Our reference 22-312-20

Date 26th October 2023

RE: CALTHORPE STREET, BANBURY – LETTER OF RESPONSE

I am writing further to your Authority's comments dated 19th July 2023 in respect of planning application 23/01633/F, which seeks permission for the redevelopment of retail units & public car park into residential dwellings.

TITLE: REFUSE VEHICLE SWEEP-PATH ANALYSIS

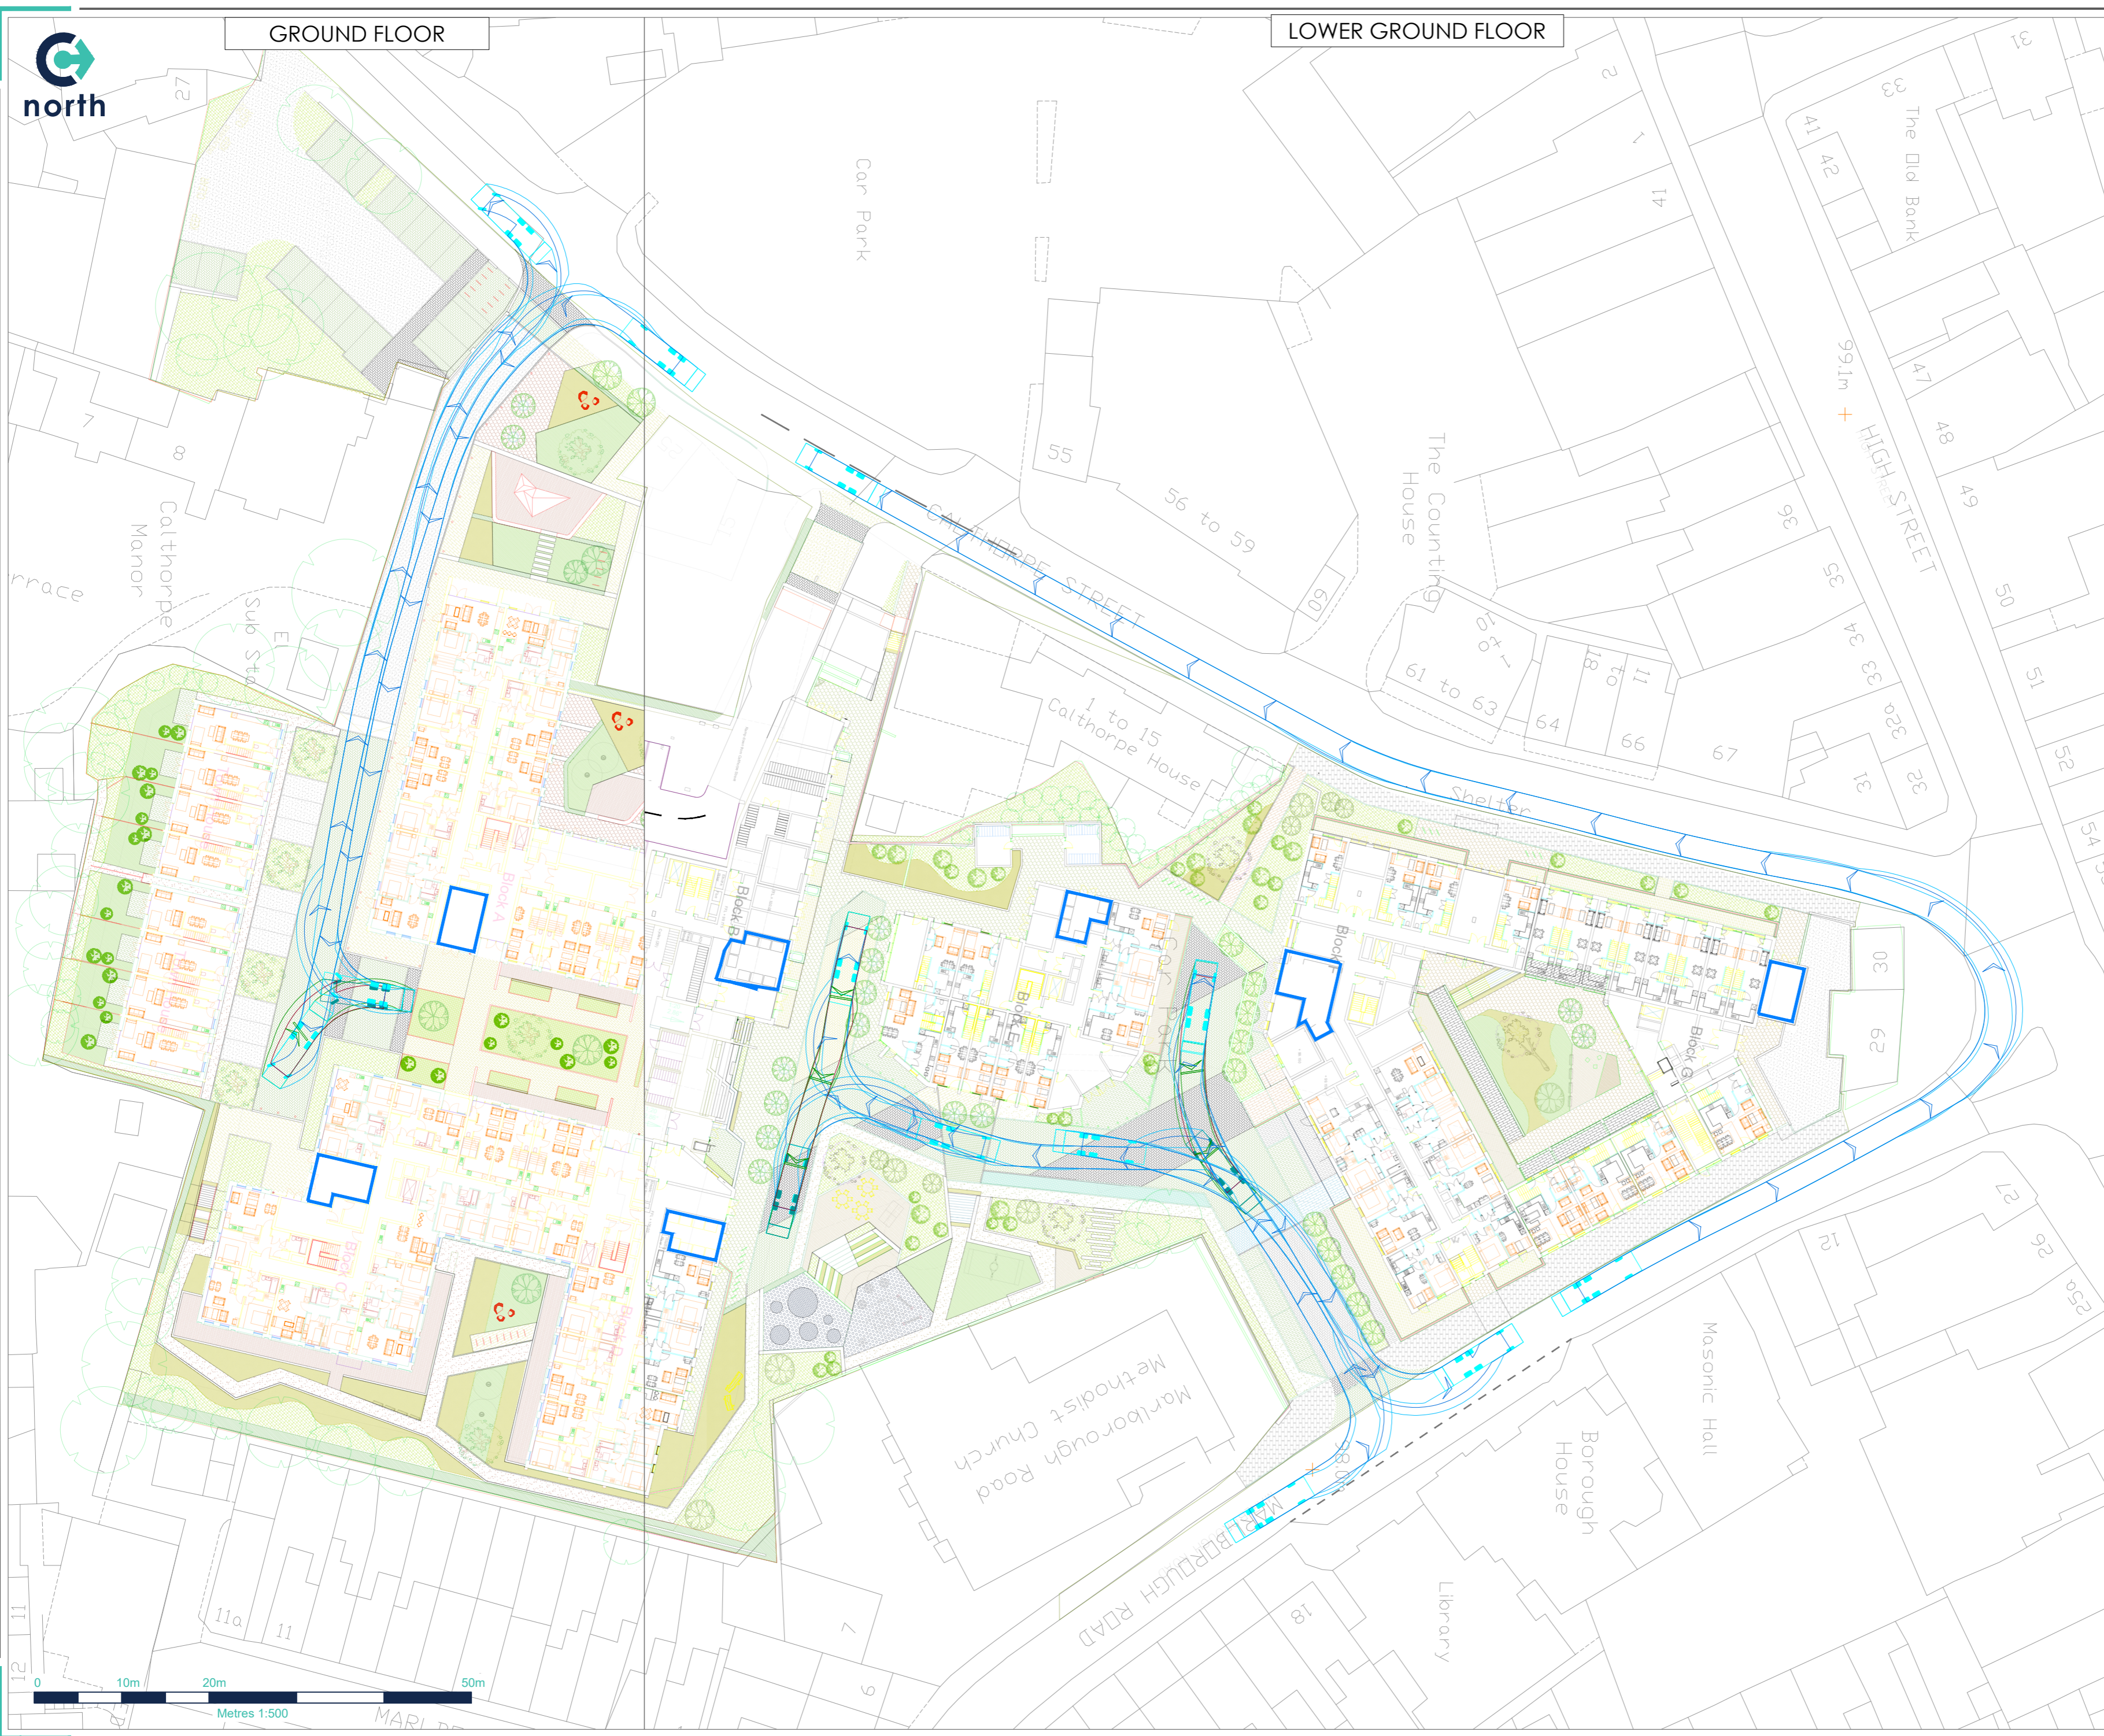
Refuse collection would be from within the development, however bin stores are not labelled on the floor plans.

There should be level or ramped routes for bins and trolleys for deliveries to residents, which do not rely on this external lift.

We have sought to clarify both the refuse and delivery stores and routes in response to the above comments from OCC. With this Corstorphine & Wright have included detailed plans showing refuse and delivery accessibility routes to the respective stores and building entrances across the site within the appended report. For confirmation, all refuse stores and main entrances for deliveries can be accessed step free and do not require use of the external lift proposed within the site.

Client: Tri7  
 Project: Calthorpe Street, Banbury  
 Drawing Title: Ground Floor Site Plan  
 Drawing Status: **PLANNING**

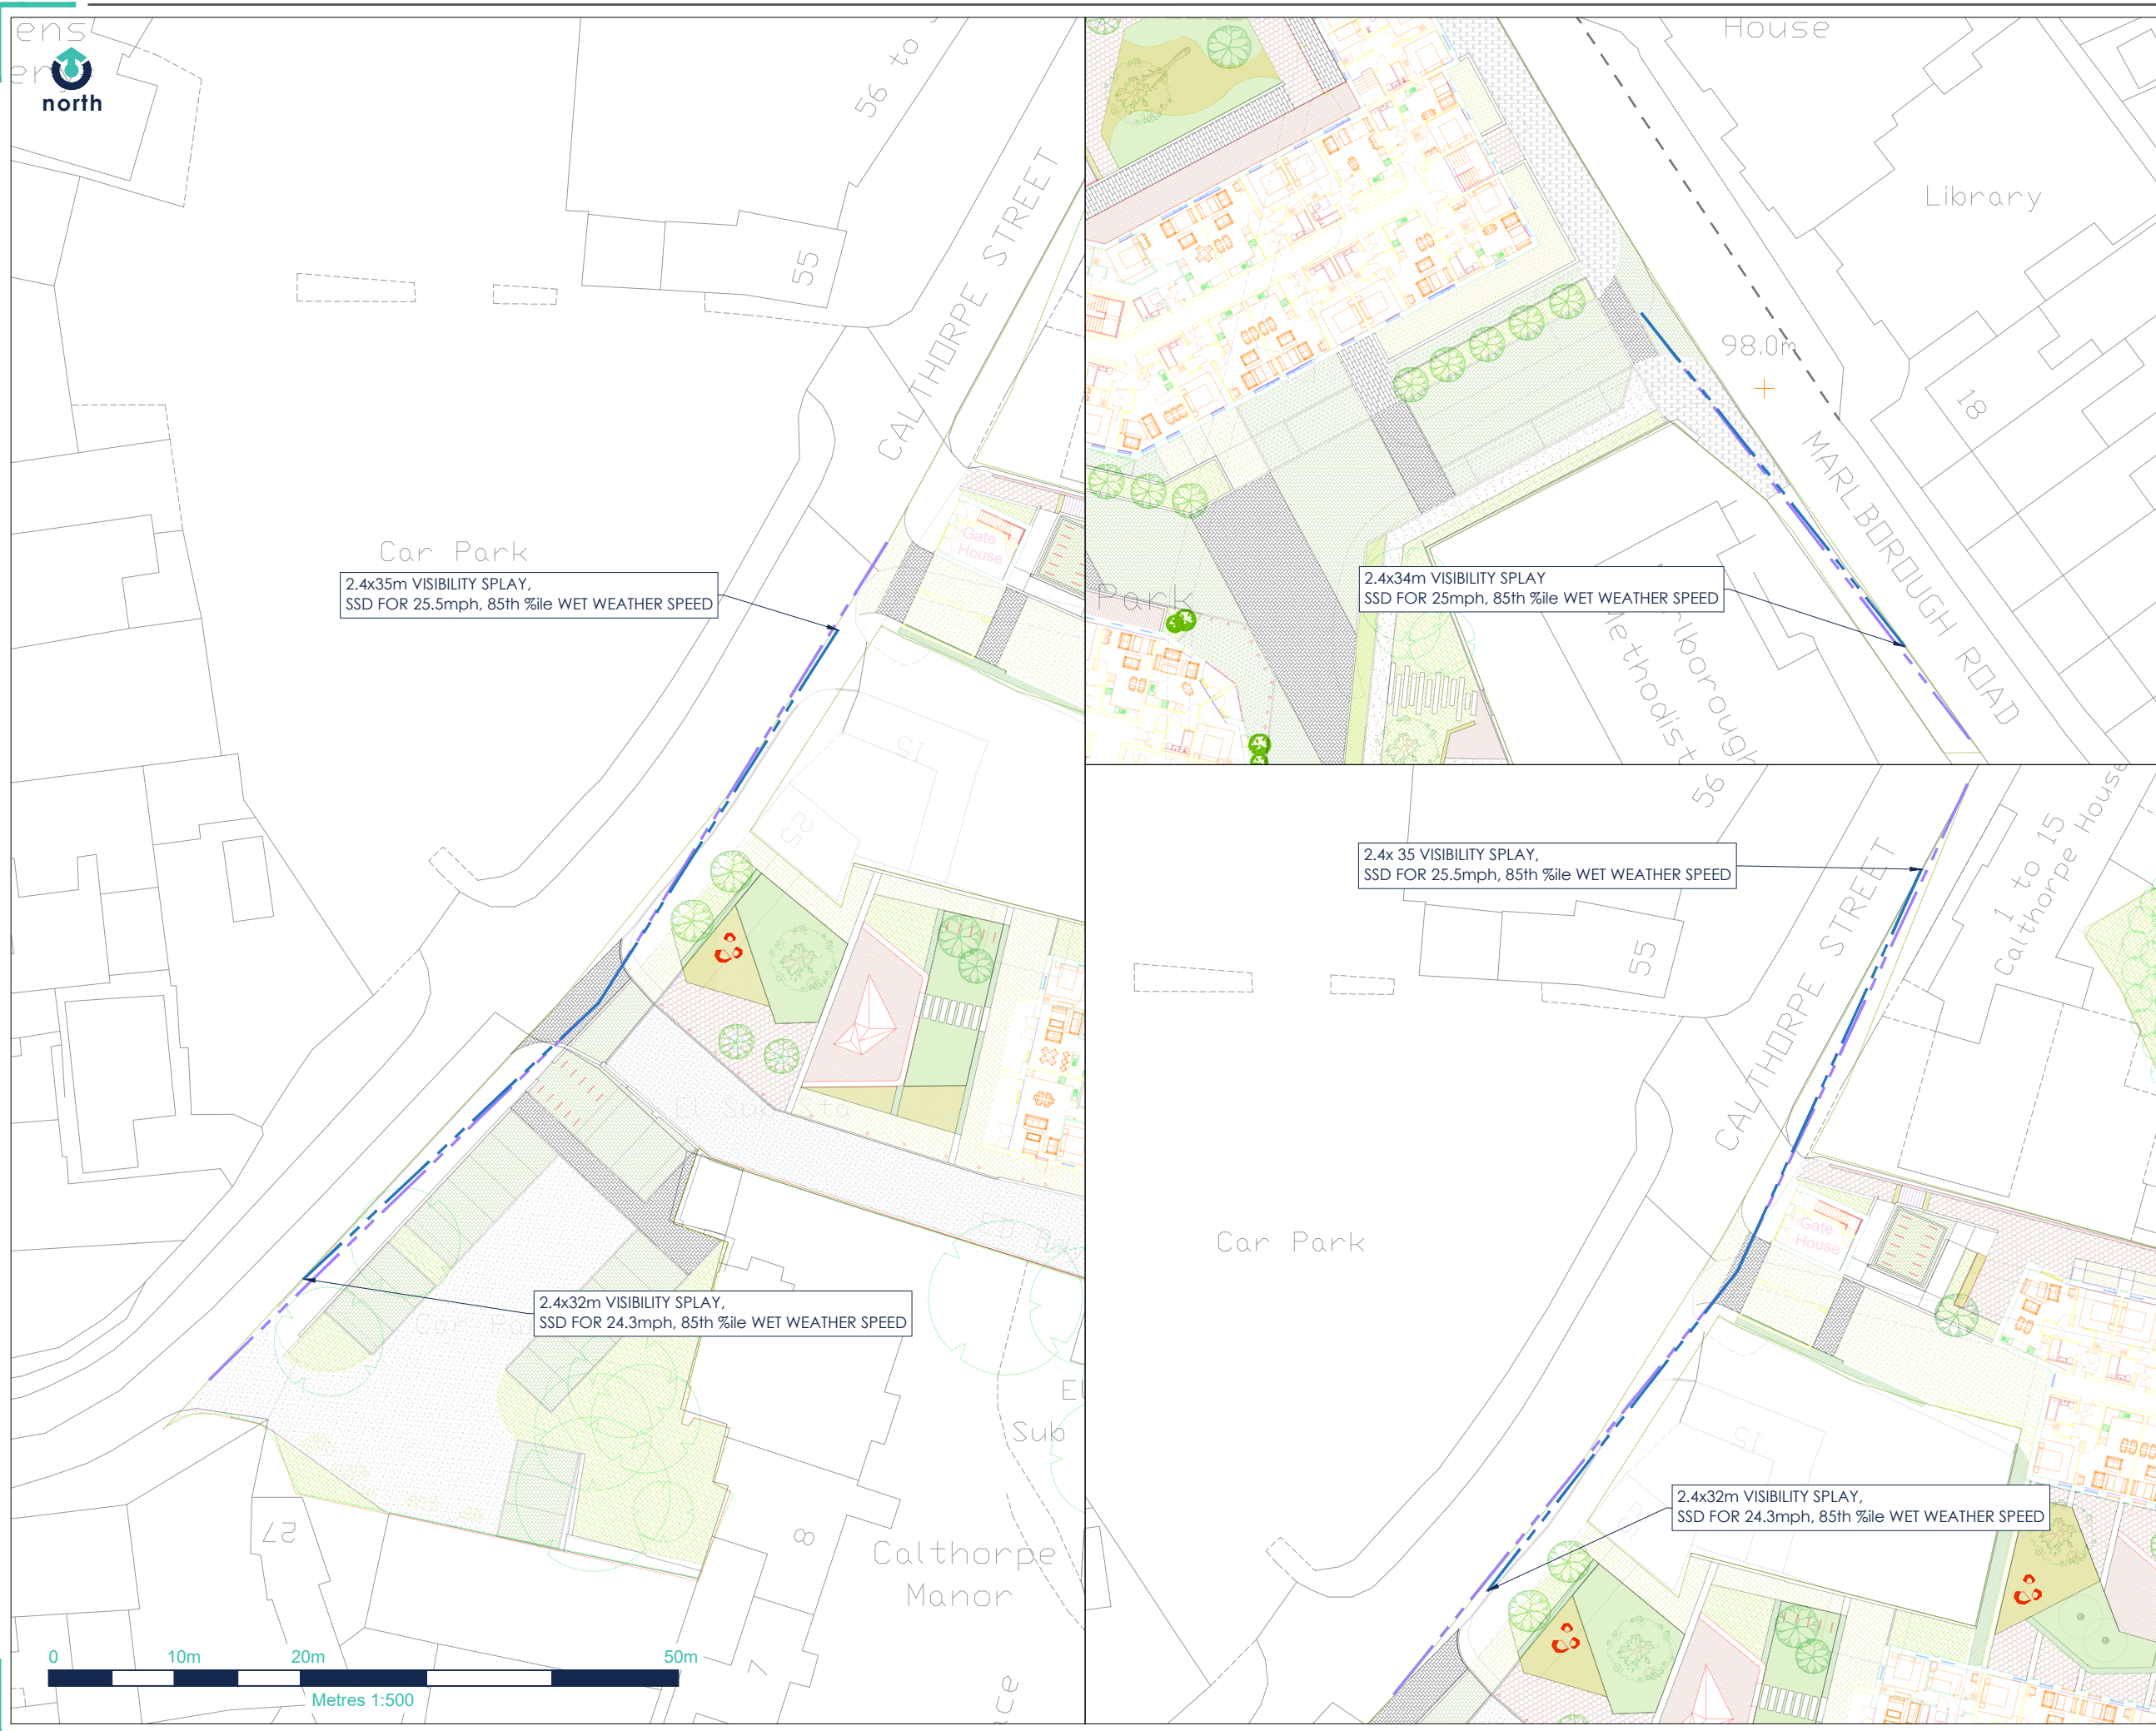
"A number of cycle stores are provided throughout the site, although their location is not clear from the floor plans, on which they are not labelled. Further detail is required to understand exactly where these stores are, how they are accessed, and the type of cycle parking within them. The OCC Parking Standards state that cycle parking should be provided in a convenient location close to building entrances and that the parking should be in the style of a Sheffield stand, not double-decked or vertical unless agreed by OCC in special circumstances."

“Covered cycle parking for the townhouses is absent from the plans and should be included.”

Following the comments, we have sought to produce plans to clarify the position of cycle stores across the site. With this, Section 1.4 of the appended Corstorphine & Wright Accessibility Report details all proposed locations – with cycle stores conveniently located; close to the building entrances and being directly accessible from outside.

With regards to the design of the cycle parking, the proposals have been amended to provide a mixture of horizontal and semi-vertical racks (91 horizontal and 197 semi-vertical racks), both types of parking available to each residential block. The semi-vertical racks can be provided with electric charging points and as such, each block will be afforded access to electric bike charging spaces.

We have sought to provide clarity on the location and type of provision in line with comments. With this, Section 1.4 (page 9) of the appended Accessibility Report outlines that cycle parking for the townhouses will be provided as covered, secured parking within the rear gardens. Each property will be able to access the rear garden separately from the house.
